# CITY OF ALBUQUERQUE

September 19, 2016

**Re: Drainage Control Ordinance (14-5-2-1) and NPDES CGP Violations for Erosion and Sediment Control and pollution - La Luz Del Oeste Unit 4**

**SILT FENCE**  
NTS

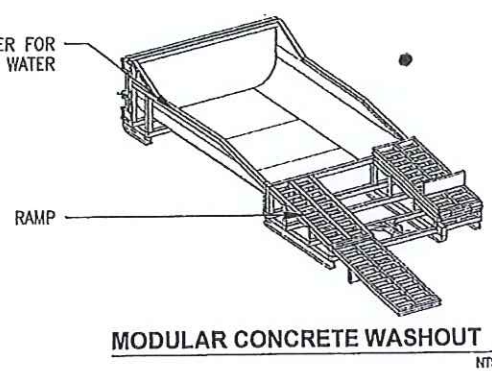
1. Construction entrance needs maintenance.
2. Multiple instances of cement pollution.
3. Silt fence was installed along Dellyne, Ave., however, it was not installed so that it would function to prevent sediment from leaving the site as it was not buried.

1. Install/maintain the silt fence at the site per approved plan.
2. Install a stabilized entrance per the approved plan.
2. Remove cement pollution material per acceptable methods.
